City of Portland, Maine - Building or Use Permit Application
 389 Congress Street, 04101 Tel: (207) 874-8703, Fax: (207) 874-8716

Permit No: 04-0207	Issue Date:	CBL: 066A B024001
------------------------------	--------------------	-----------------------------

Location of Construction: 33 Roberts St	Owner Name: Ayer Nancy I	Owner Address: 33 Roberts St # 2	Phone: 207-772-5279
Business Name: n/a	Contractor Name: Joe DiFrancesco	Contractor Address: Portland	Phone: 2078785723
Lessee/Buyer's Name: n/a	Phone: n/a	Permit Type: Additions - Multi Family	Zone:

Past Use: Multi Family / 3 units	Proposed Use: 3 units / build 12' x 16' second floor deck.	Permit Fee: \$84.00	Cost of Work: \$6,350.00	CEO District: 3
Proposed Project Description: Build 12' x 16' second floor deck.		FIRE DEPT: <input type="checkbox"/> Approved <input type="checkbox"/> Denied	INSPECTION: Use Group: Type	
		Signature:	Signature:	
PEDESTRIAN ACTIVITIES DISTRICT (P.A.D.)				
Action: <input type="checkbox"/> Approved <input type="checkbox"/> Approved w/Condition <input type="checkbox"/> Denied				
Signature:		Date:

DECK
3' 0" x 6' 8"
2x8 header
Full glass
metal
swinging in the
house.

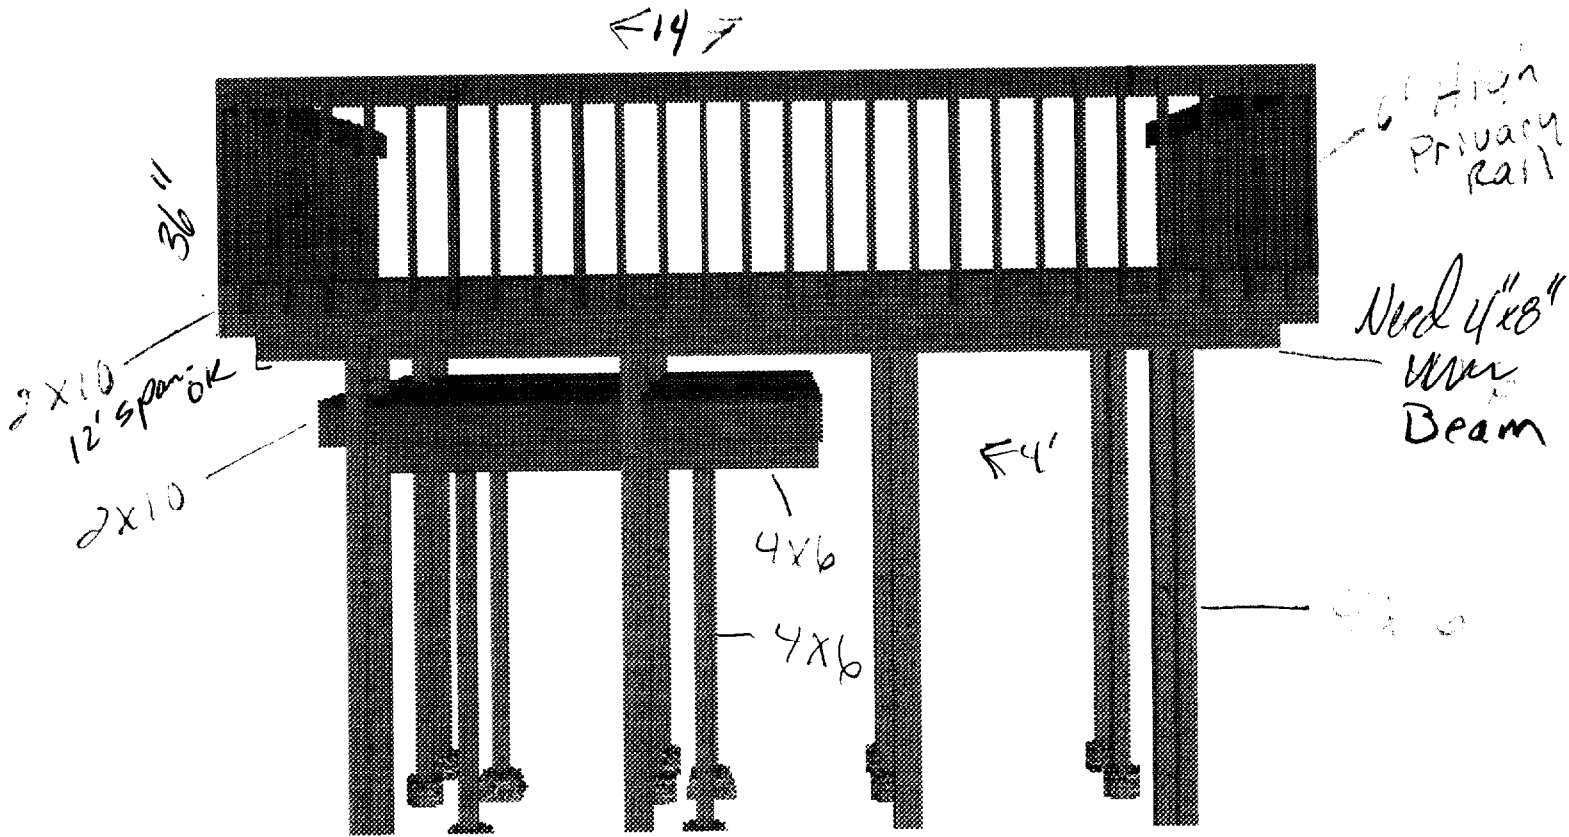
Comments:
3/12/04-tmm: Does not meet setbacks - left message w/builder - put in hold pile
3/2/04-kwd: Need header and existing wall detail for slider installation to deck. GG to call. Kwd
3/26/04-tmm: Revised plan and reduced deck size - ok to issue.
